## Parking & Service Management Plan

1 Whittingham Road  
Longridge  
Preston  
PR3 2AA

**October 2025**

The purpose of this document is to address LHA’s consultation response for **Planning Application Reference 3/2025/0605**, particularly the request for an Internal Parking Layout Plan and Service Management Plan. The document should be read in conjunction with all other drawings and information submitted by Tang & Associates Ltd.

- 9916/102D – Existing & Proposed Site Plans

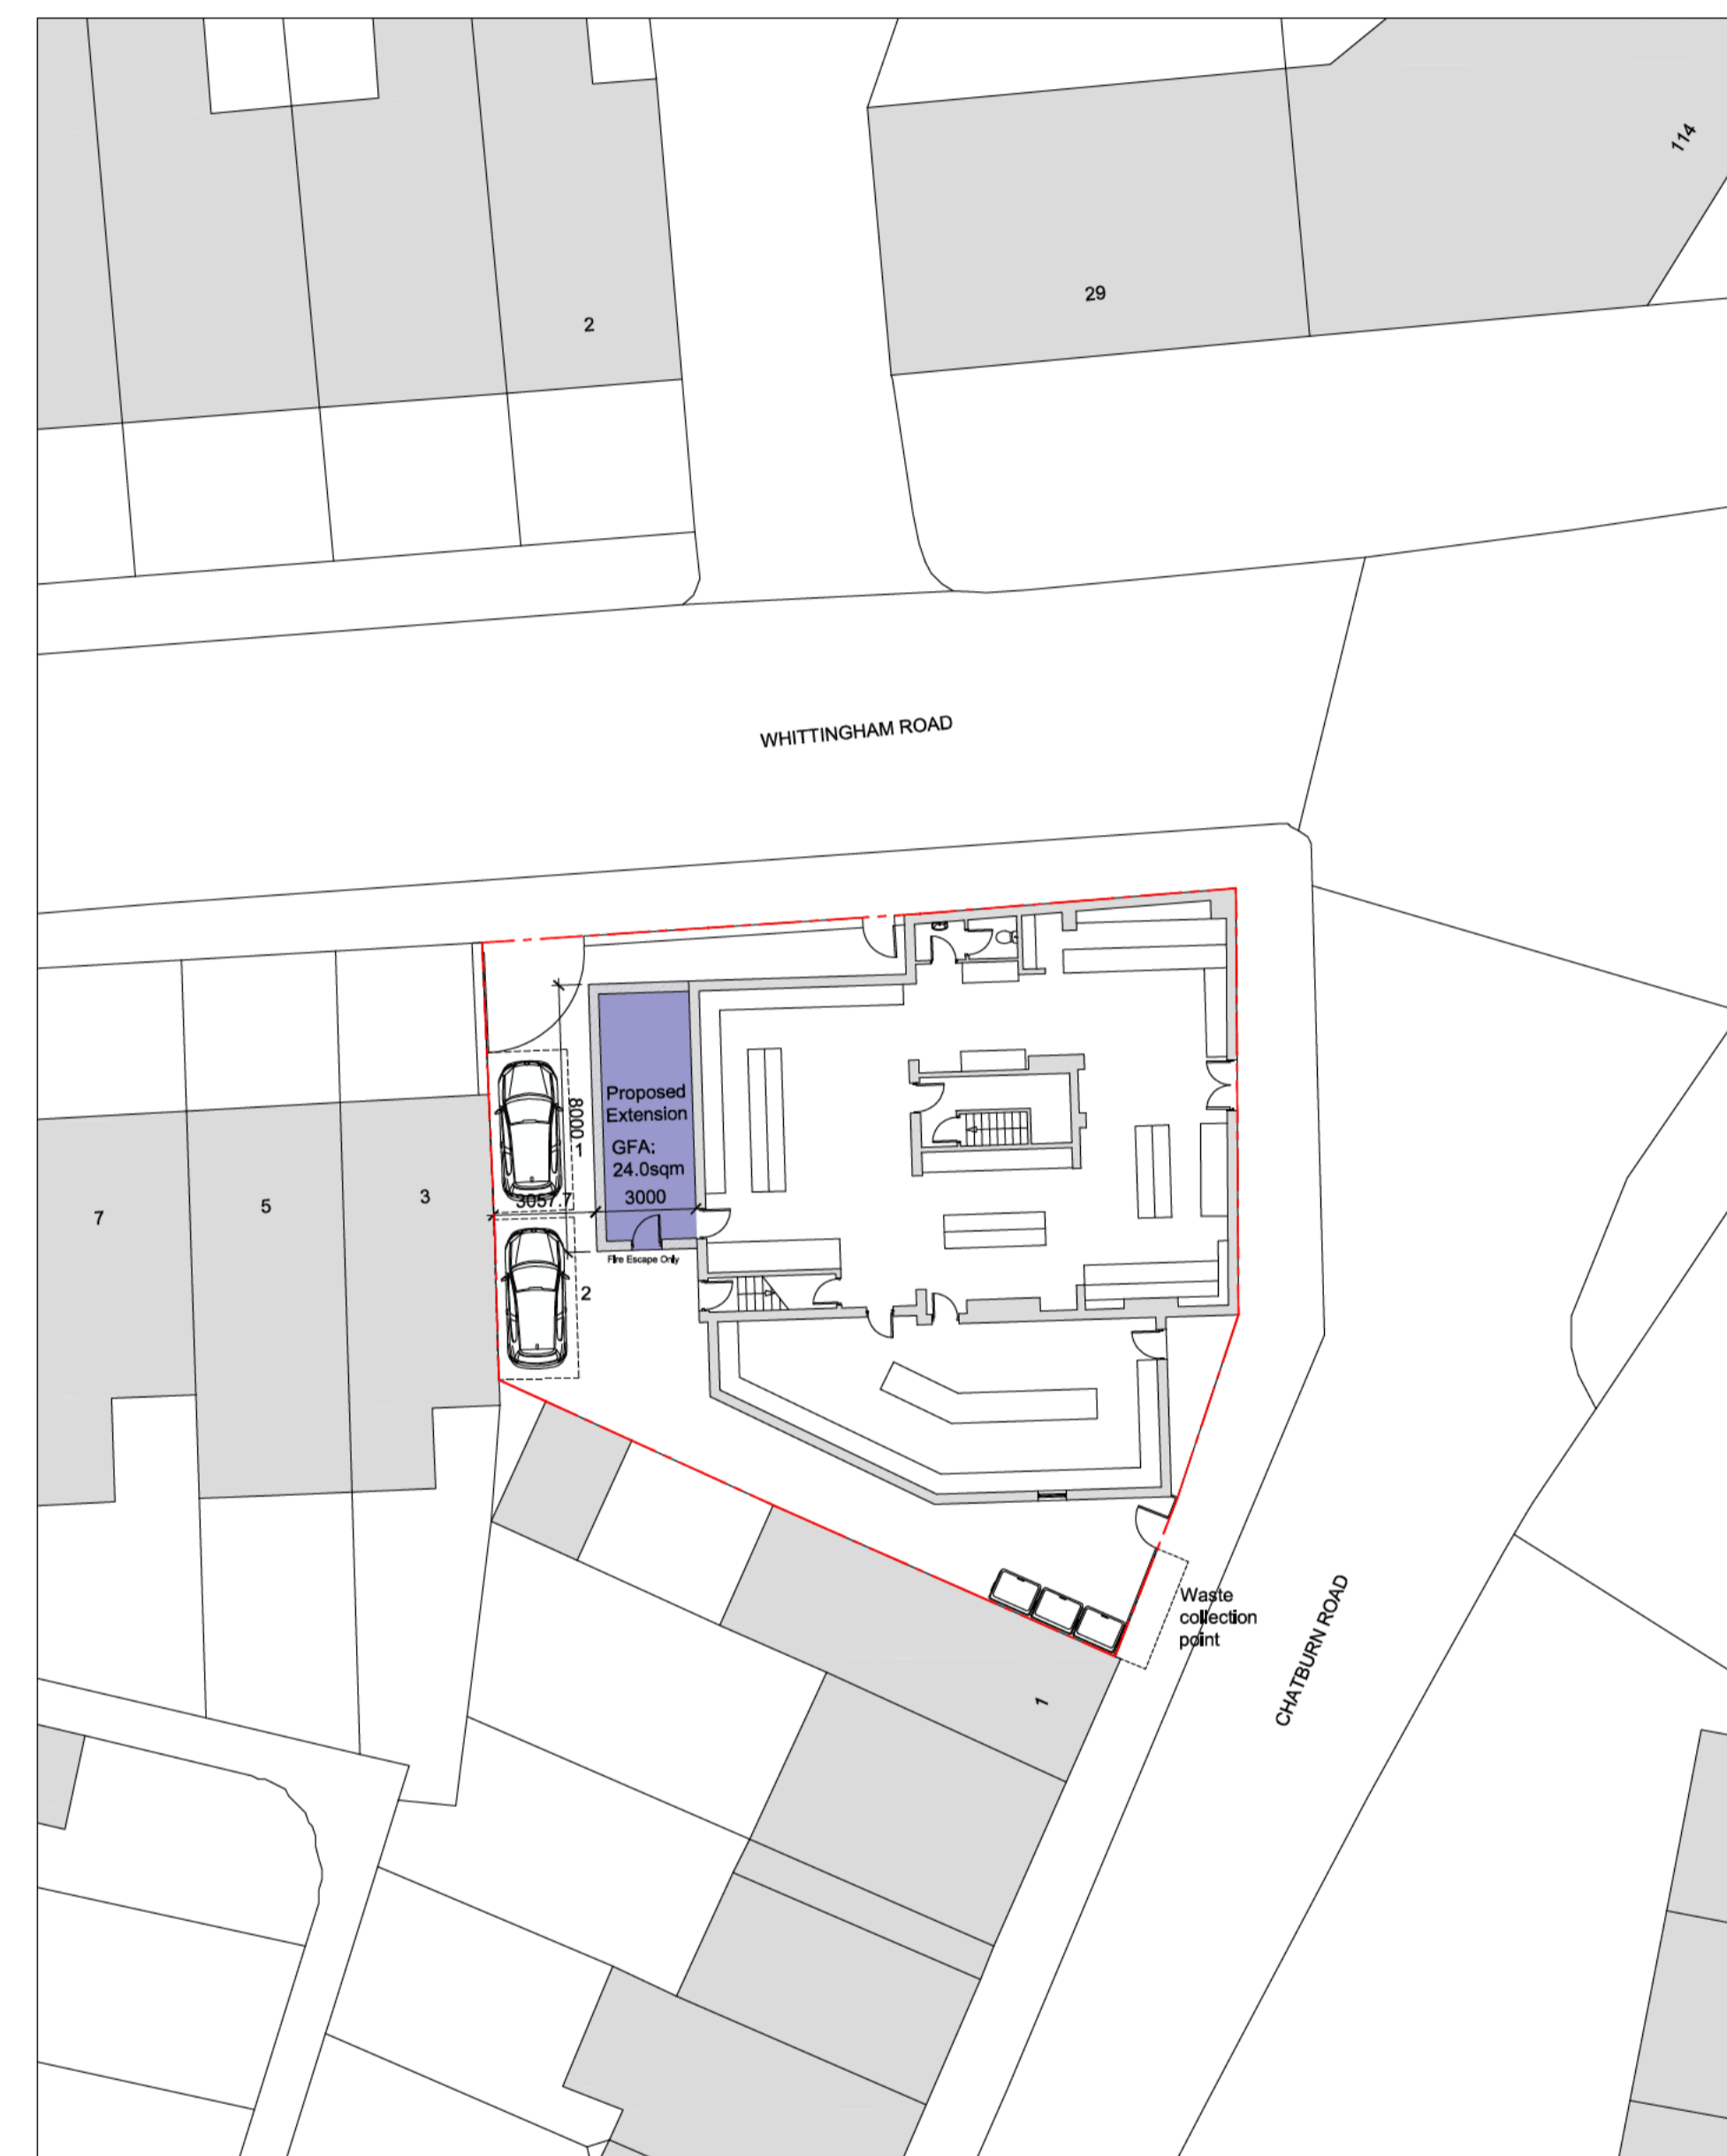
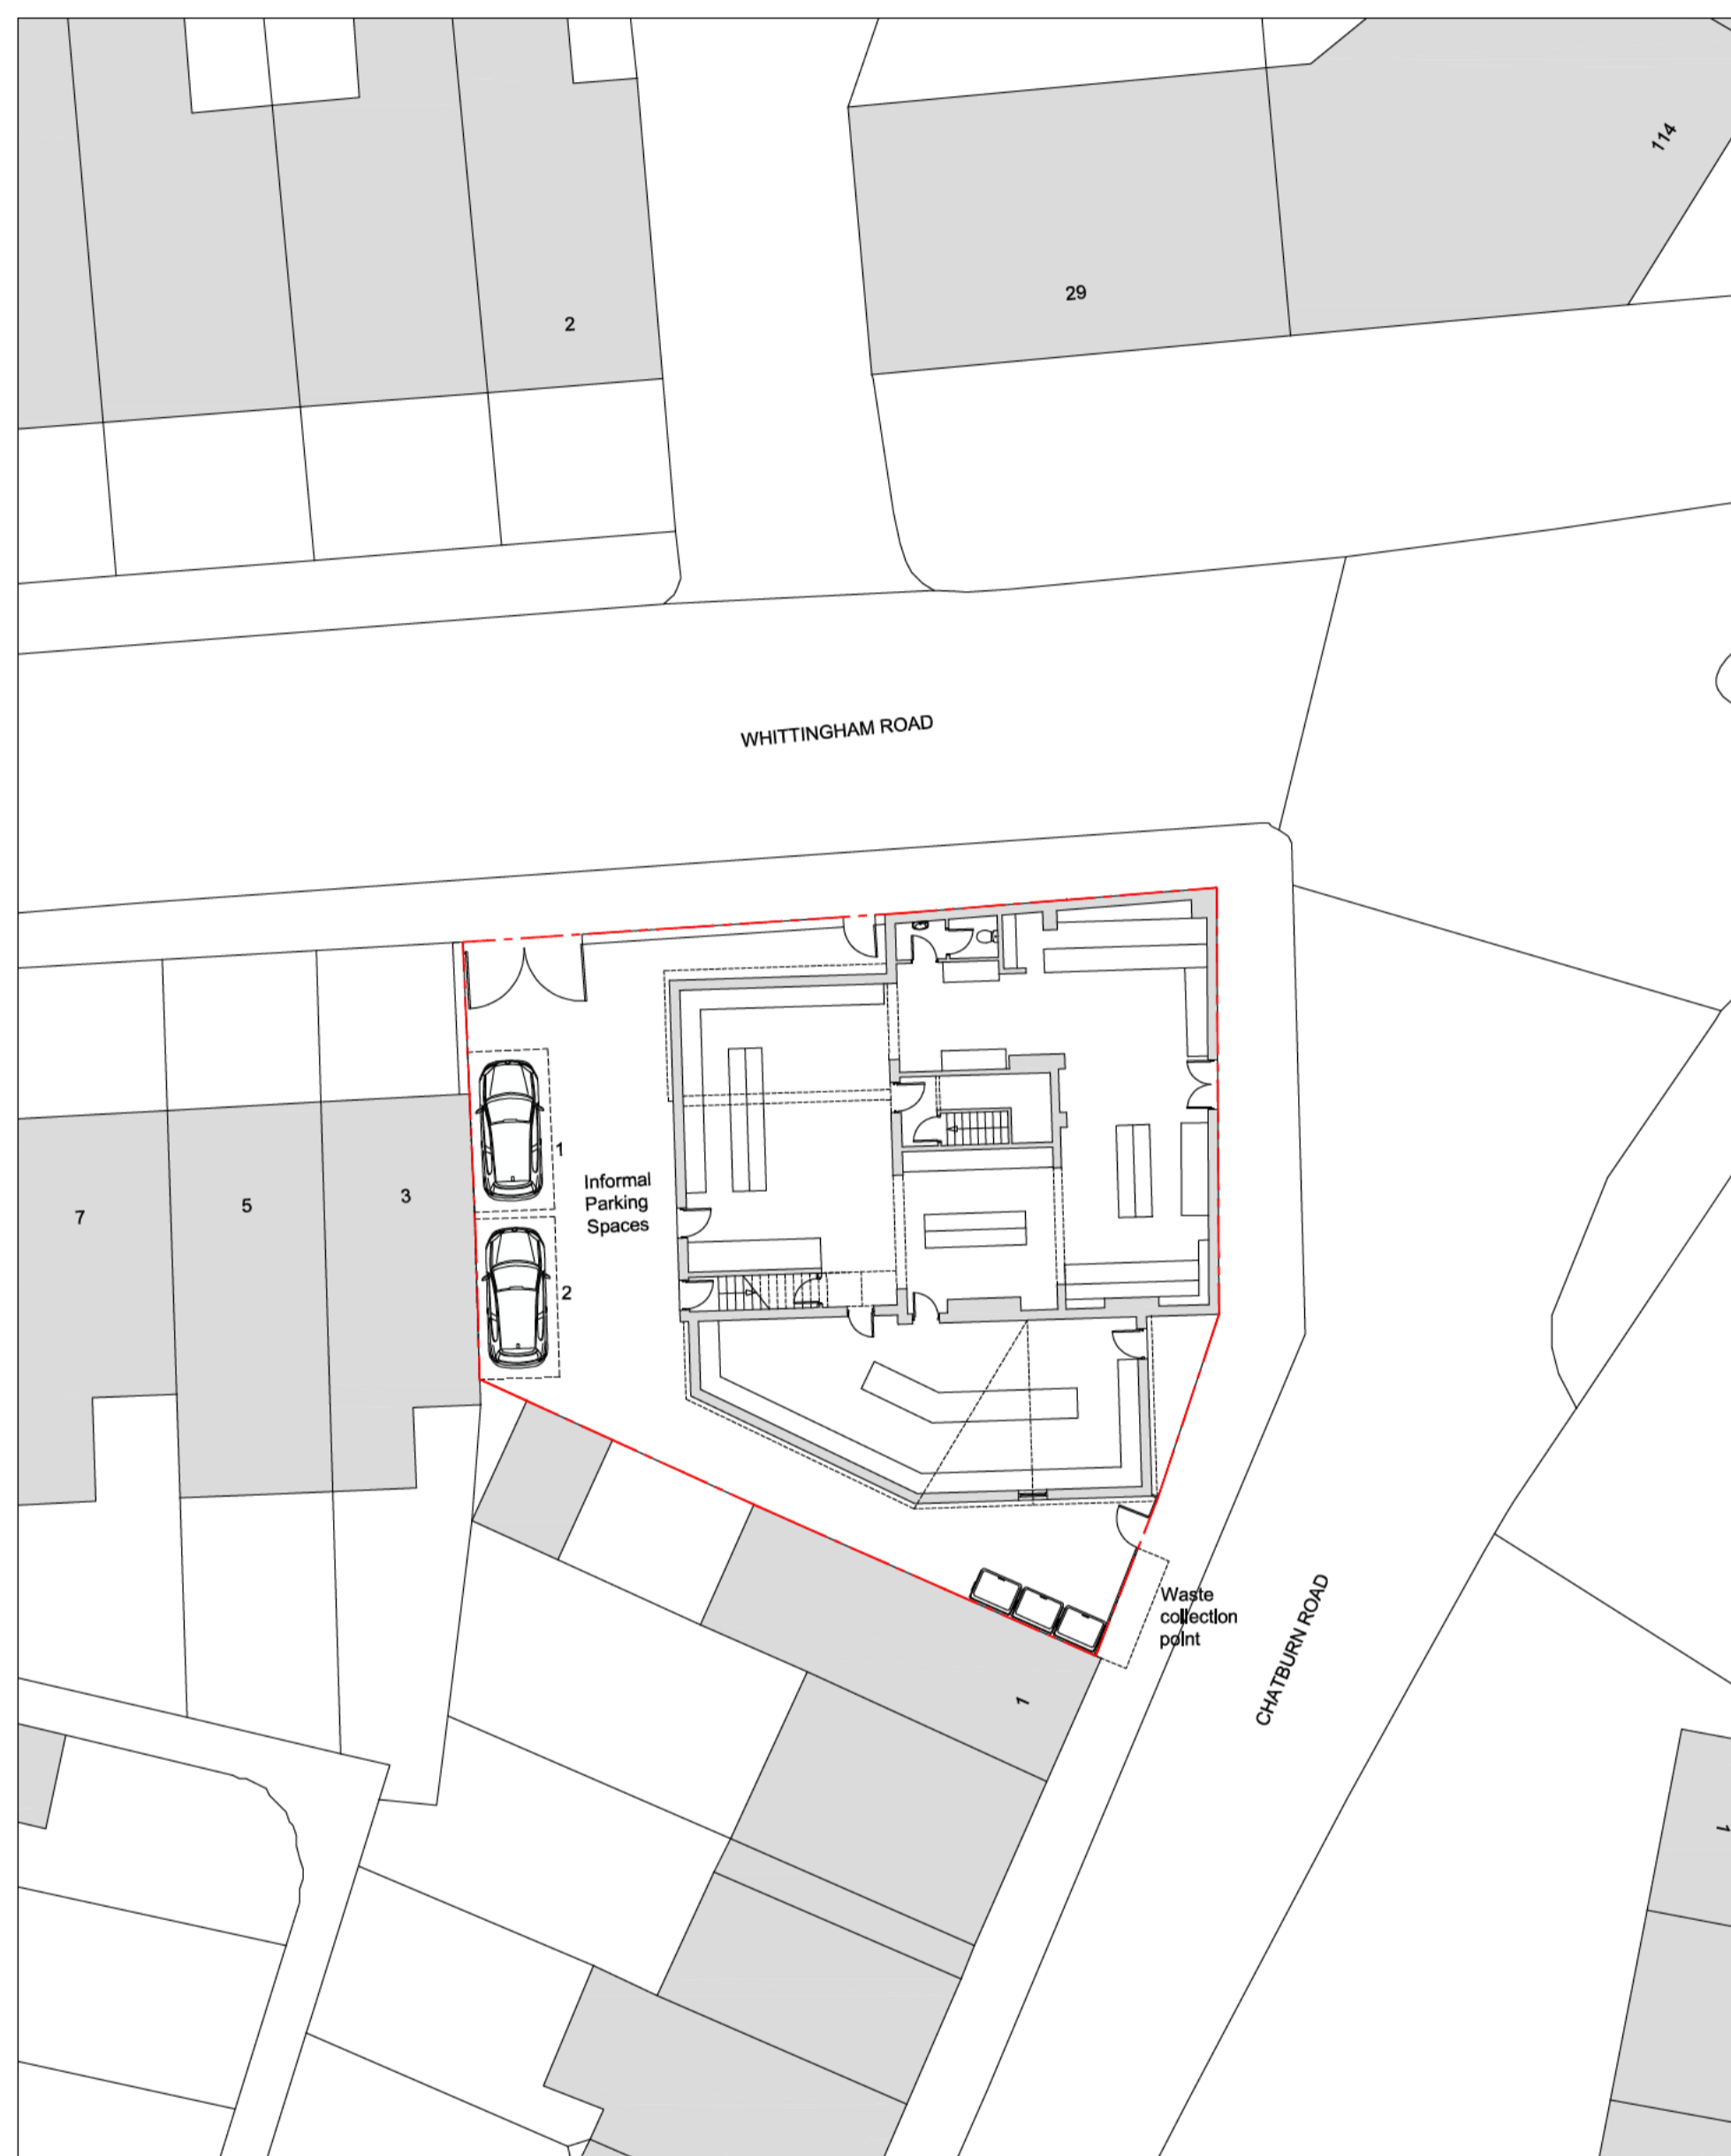
*Internal Layout The site forms a shop on the ground floor level and a 4-bedroom dwelling on the first floor. A 4-bedroom dwelling should be provided with 3 off-street car parking spaces. These spaces should measure a minimum of 5m in length and 2.4m wide each, where they are adjacent to a fence or similar obstruction an additional width of 0.6m should be provided. As stated within the LHAs parking standards as defined in the Joint Lancashire Structure Plan. The shop would also benefit from internal parking provisions and internal servicing due to its location at the junction of Whittingham Road and Chatburn Road. Given the number of terrace properties and those without access to off-street parking on both Whittingham Road and Chatburn Road, there is likely to be a high demand for on-street parking in the area. The proposal will remove access to off street parking provision, intensifying the demand for on-street parking within the area. In order to mitigate this concern, the applicant should provide an internal parking plan and a service management plan detailing how the shop will be serviced should the proposal be supported.*

In response to the internal parking concern raised by the LHA, the first-floor 4-bedroom flat has historically operated without dedicated off-street parking. This is an existing site condition, not introduced by the current proposal. The site presently accommodates two informal spaces in the rear area, generally used by the shop owners. The area is not large enough to accommodate three compliant bays (5.0 m × 2.4 m each plus manoeuvring space) while still allowing safe access.

As shown in Figure 2, the proposal retains the existing informal parking spaces, resulting in no change to on-site parking provision. These spaces are used on an ad-hoc basis by the shop owners and are not formally designated or relied upon for customer or residential use. Therefore, it will not increase traffic generation or on-street parking demand. The proposal is a modest (c. 24 m<sup>2</sup>) ancillary storage extension to the existing shop and does not increase customer floorspace, staffing levels, or delivery frequency.
